**From:** Planning  
**Sent:** 26 September 2019 13:44  
**To:** DC Support  
**Subject:** FW: Planning ref: 19/01740/HYBRID. Land Adj to Promised Land Farm Wendlebury Rd Chesterton.

**Planning ref: 19/01740/HYBRID. Land Adj to Promised Land Farm Wendlebury Rd Chesterton.**

CYCLE SHELTER DETAIL

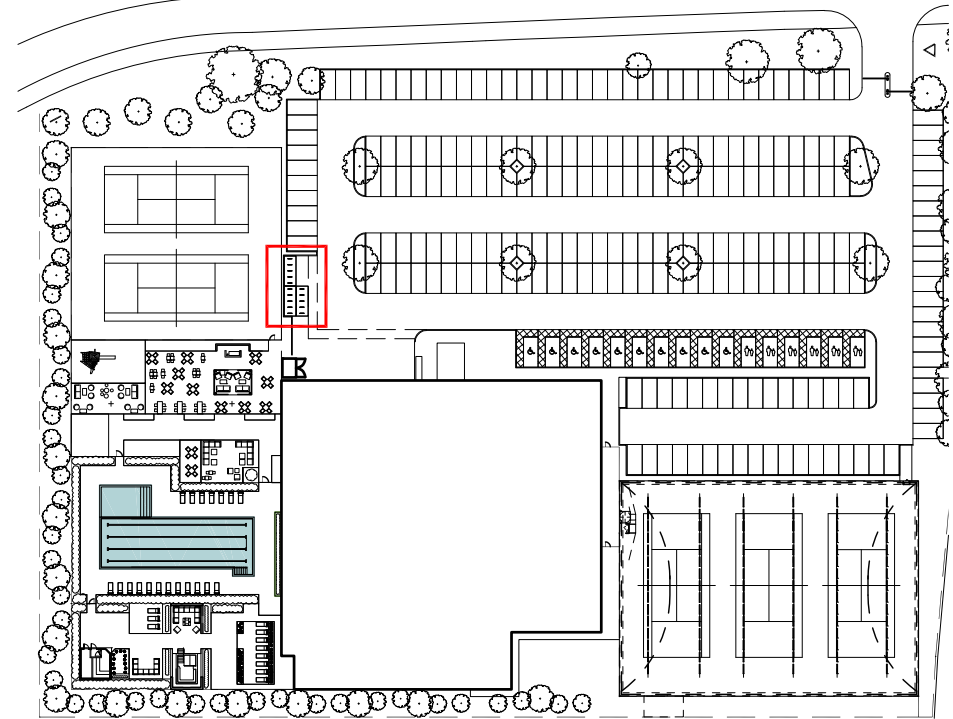
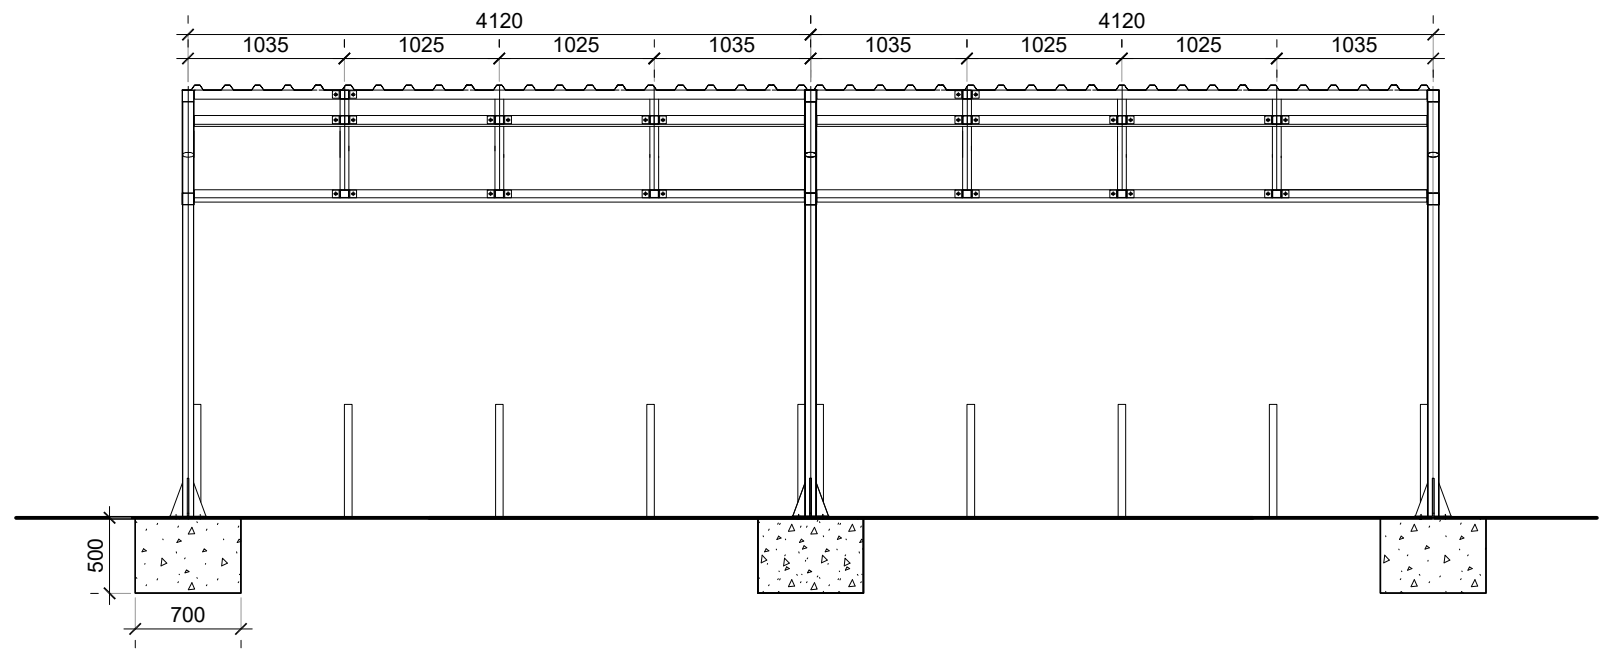
- The cycle shelter is not well overlooked and offers little protection to the cycles of employees or club members visiting for any real length of time. I recommend that a secure, enclosed facility replace the one proposed or the shelter is relocated behind the secure fence line.
